Project Name: **Sunshine West II**☒Scheduled with DRC on **September 21, 2016 (Wednesday)** at **1:30 p.m.**☐

Project Location: **4101 Blake Road SW**

Re: Sunshine West – Subdivision II Drainage Plan
Engineer's Stamp dated 5/20/11 (N10/D008)

Re: Sunshine West II MHP Grading Plan
Engineer's Stamp dated 1-14-11

DRAINAGE PLAN
SUNSHINE WEST - SUBDIVISION II
4101 BLAKE ROAD SW
PND - 200110002
CSU - 60006

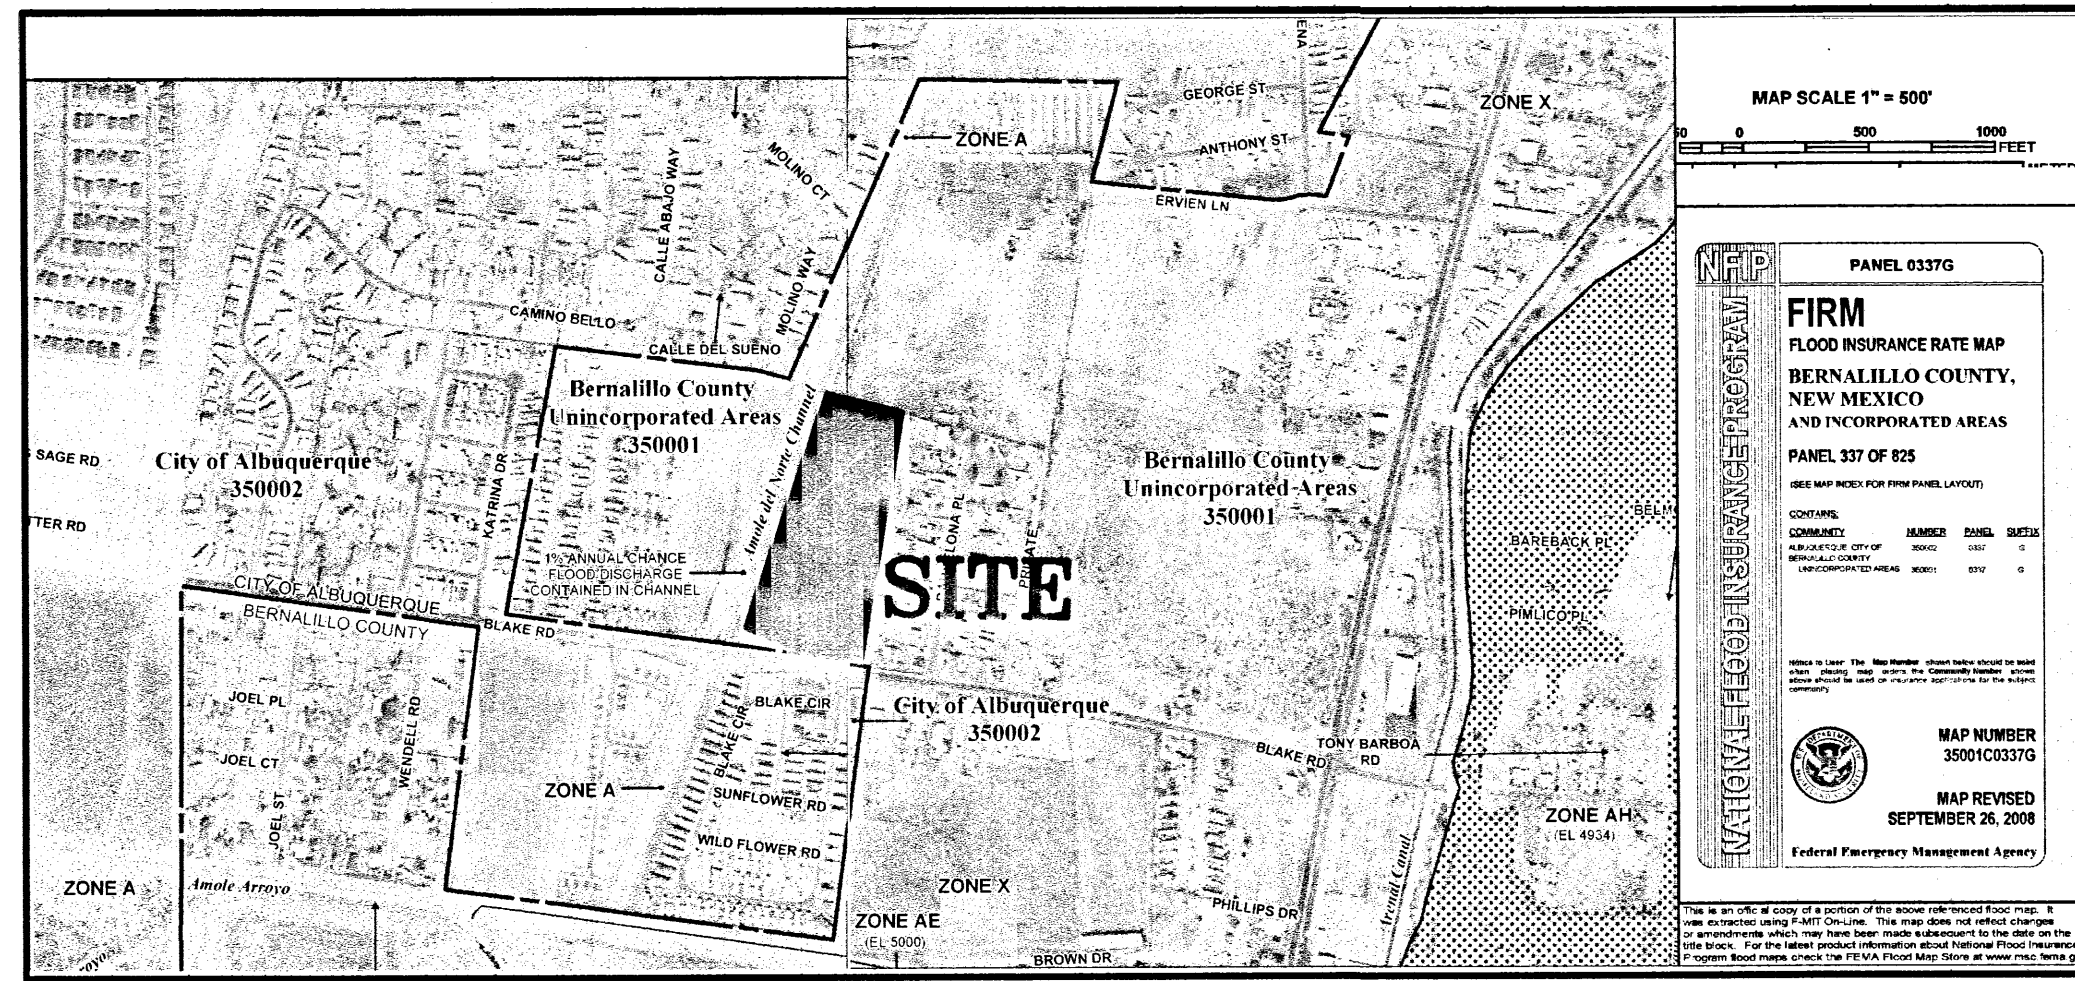
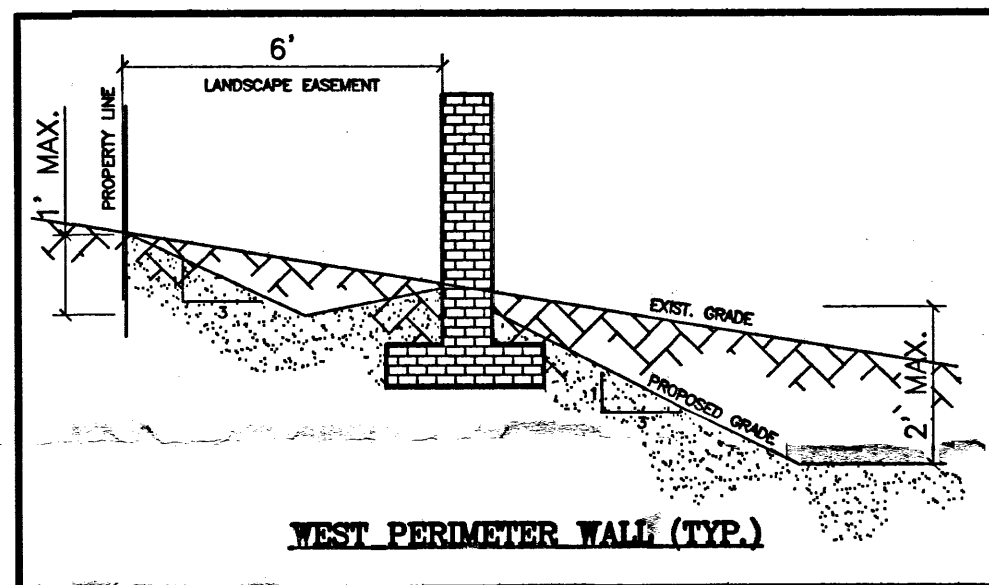
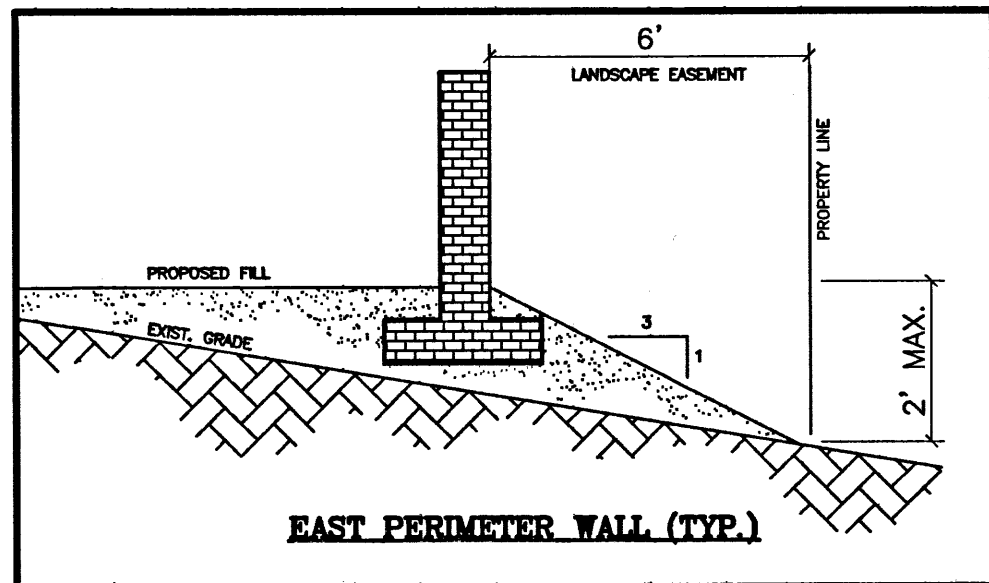
However, I cannot approve the plan. The comment to "Add a note to the storm drain that will penetrate the Amole Del Norte channel..." was not added. There is a general note "Storm drain to be built by separate COA Work Order." This is not the same. The onsite storm drain is private. Just the piece that goes into the channel is to be built by Work Order.

This plan should be fixed before submitting construction plans to DRC. That way we can have an approved Grading Plan, For Information Only, in the Work Order set.

I am in receipt of your letter dated May 9, 2011 and have addressed your comments. I added the note concerning the COA Work Order and upgraded the notes to reflect the 18-inch storm drain. Upon your acceptance of the updated drawing, please forward a letter for Don Briggs stating that the concept is acceptable. Don needs to be aware that we may discharge into the Amole Channel and that we may discharge Basin 6 into Blake Road.
